Aldington and Bonnington Parish Council Written Representation, 10 December 2024

APPENDIX C - INDEPENDENT RESPONSE TO THE LANDSCAPE AND VISUAL IMPACT ASSESSMENT

Evolution Power application to the Secretary of State for consent for the Stonestreet Green Solar Electricity Generation Development, Reference EN010135 (Nationally Significant Infrastructure Project)

Independent Response to the Landscape and Visual Impact Assessment submitted as evidence to the Planning Inspectorate, prepared for Aldington & Bonnington Parish Council

STONESTREET GREEN SOLAR
STREETS, RIGHTS OF WAY
AND ACCESS PLANS
142-02-71 REV. 01
SHEET 3 OF 10
APPF Regulation 5(2)(k)

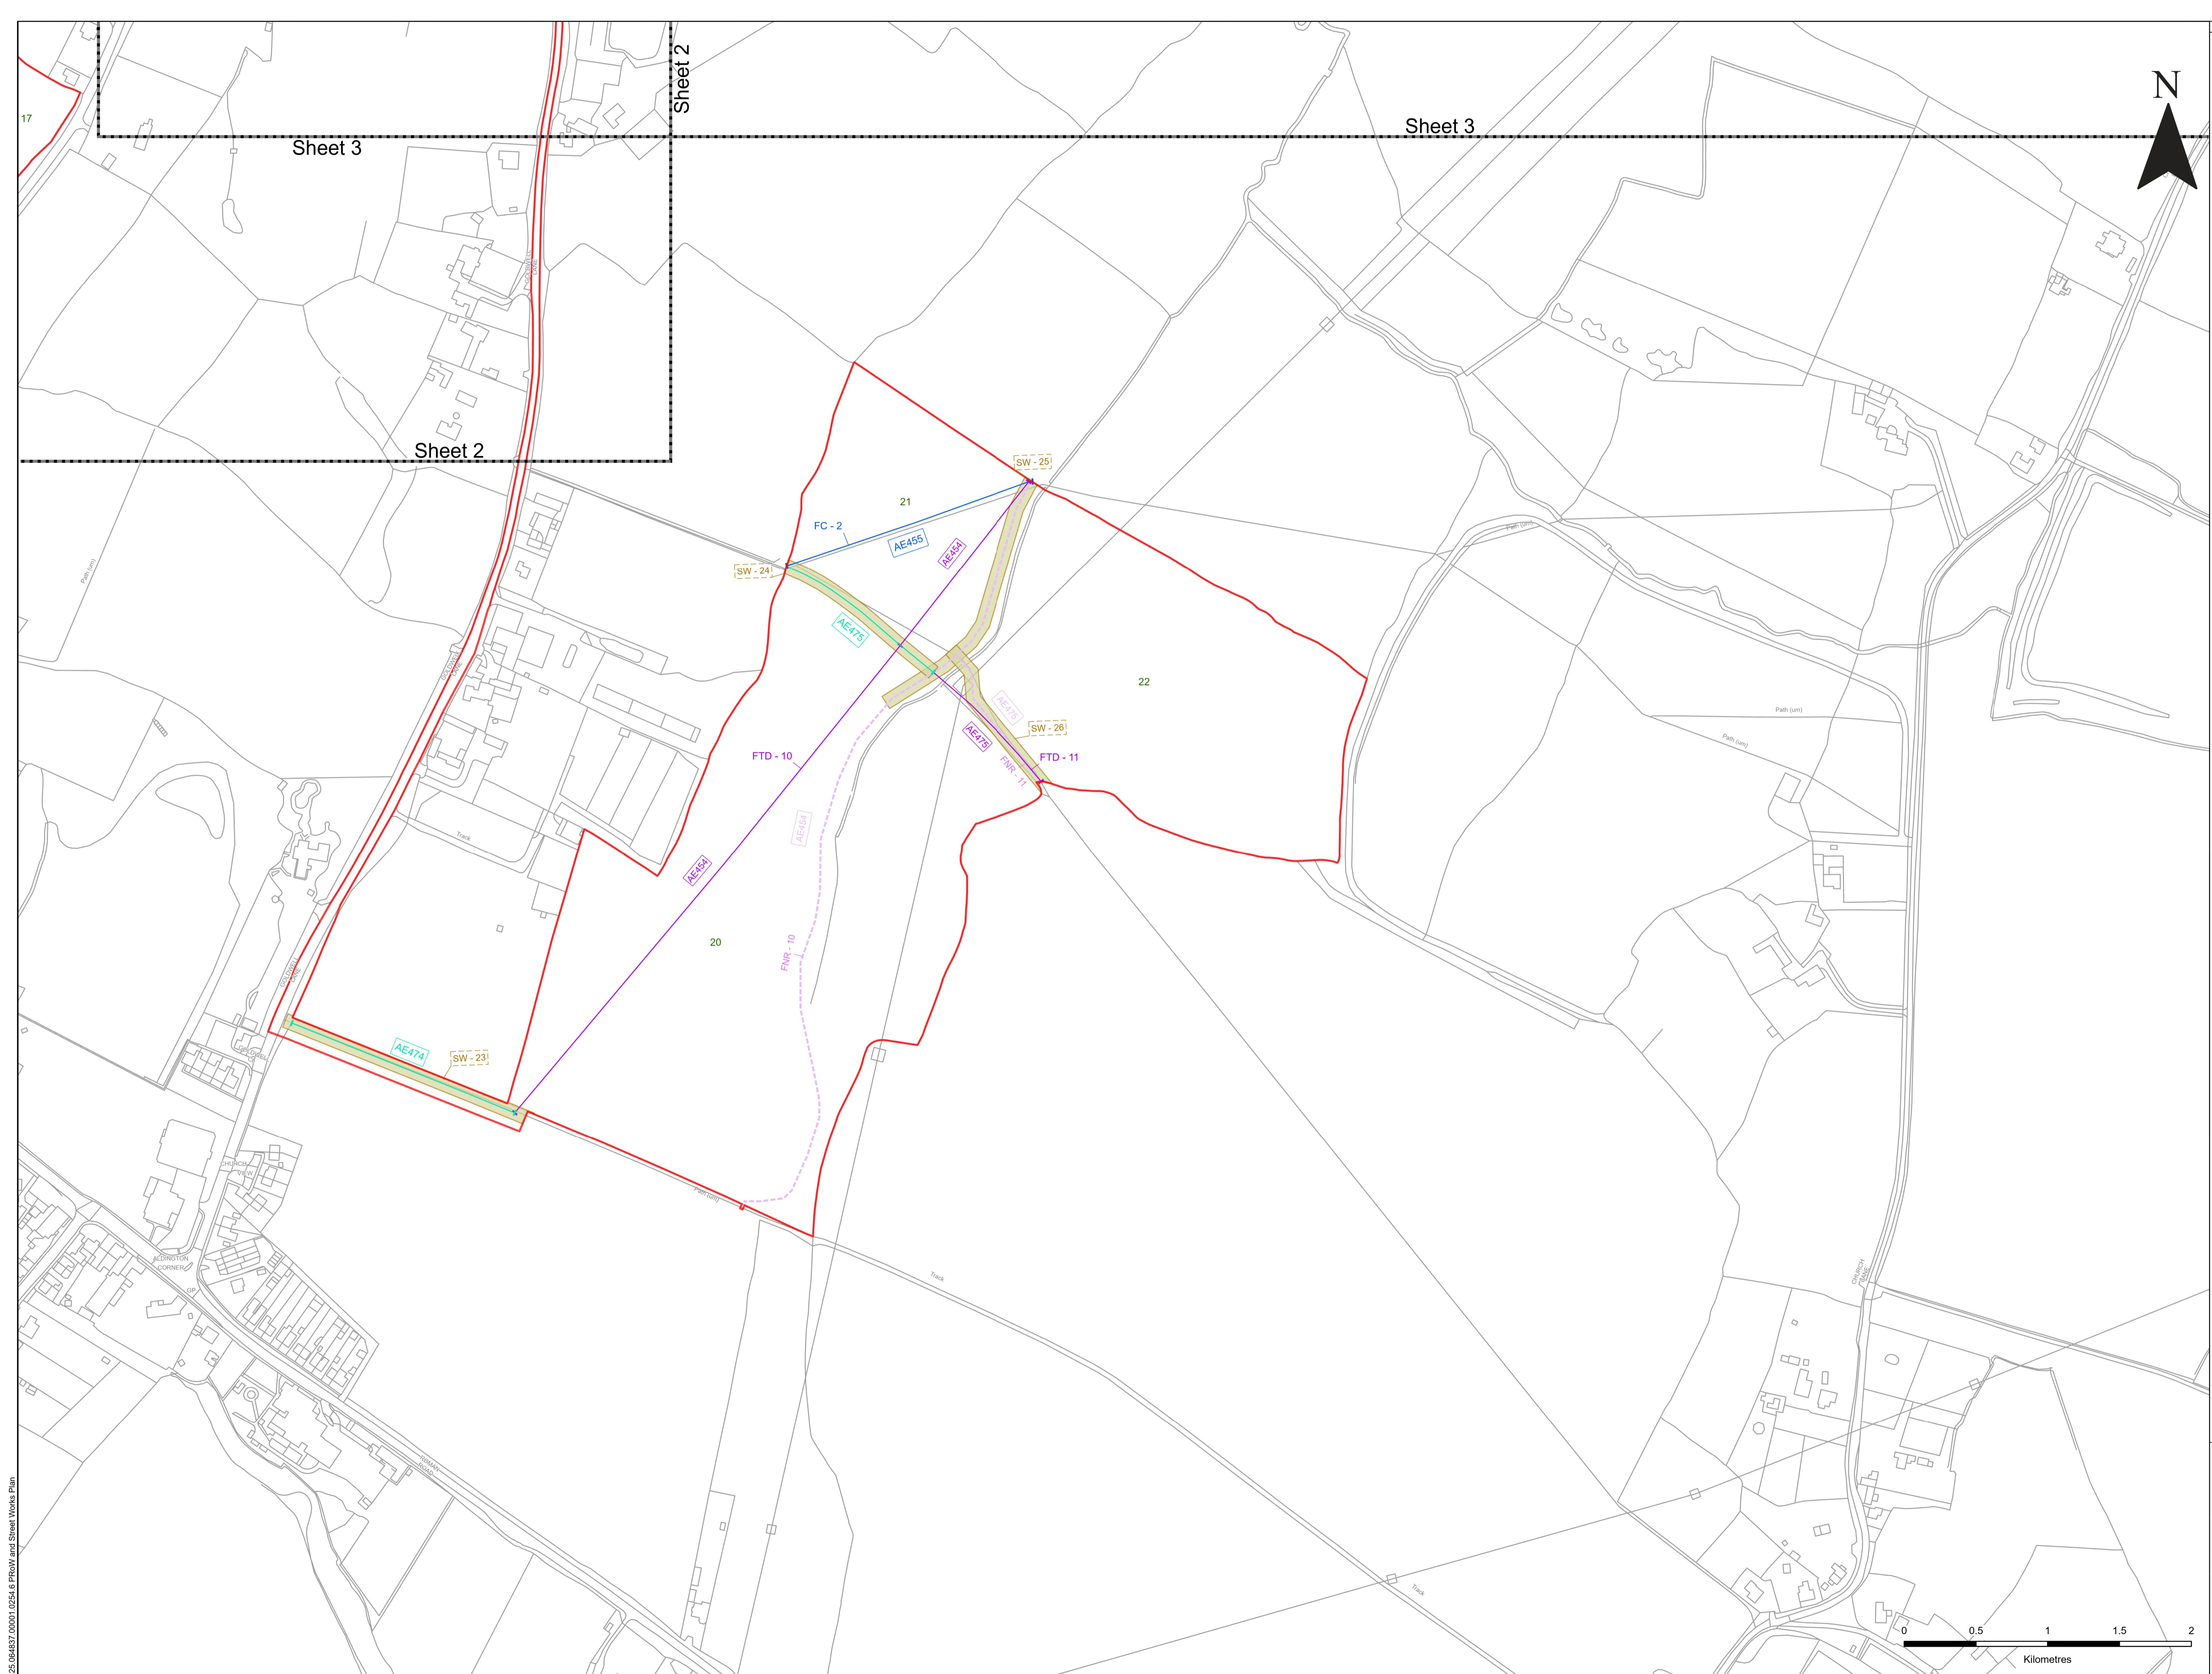
D – relates to the views enjoyed by walkers going in both directions on the popular AE474 path linking Goldwell Lane in the modern village with the Church Lane Conservation Area at St Martin’s Church. Its elevated, open situation provides extensive views to the village and the church, as well as towards the East Stour River valley and the Kent Downs. A section of this path runs along the southern edge of the south-westernmost part of the Proposed Development, which would overshadow the path and transform the experience of using it. Users of AE454, which runs north-east from AE474, would find even more significant changes, with the path re-routed into a dip in the hillside, with solar arrays obliterating views on both sides. AE475, running between Church Lane and the lower part of Goldwell Lane, i.e. to the north of AE474, provides even better views over the East Stour River valley and the Kent Downs, as well as Bested Hill. This panorama would be affected significantly by the proximity to the near-distance solar arrays, as well as the more distant ones west of Calleywell Lane.

E – takes into account the potential changes to near-distance views for walkers on the low-lying paths around the northern edge of Backhouse Wood (AE457 and the northern end of AE657), which would come about if the Proposed Development proceeds. Walkers would be hemmed in between the enclosed wood on one side, and the dense arrays of solar panels on the other side, rather than having the open outlook to the north that they currently experience.
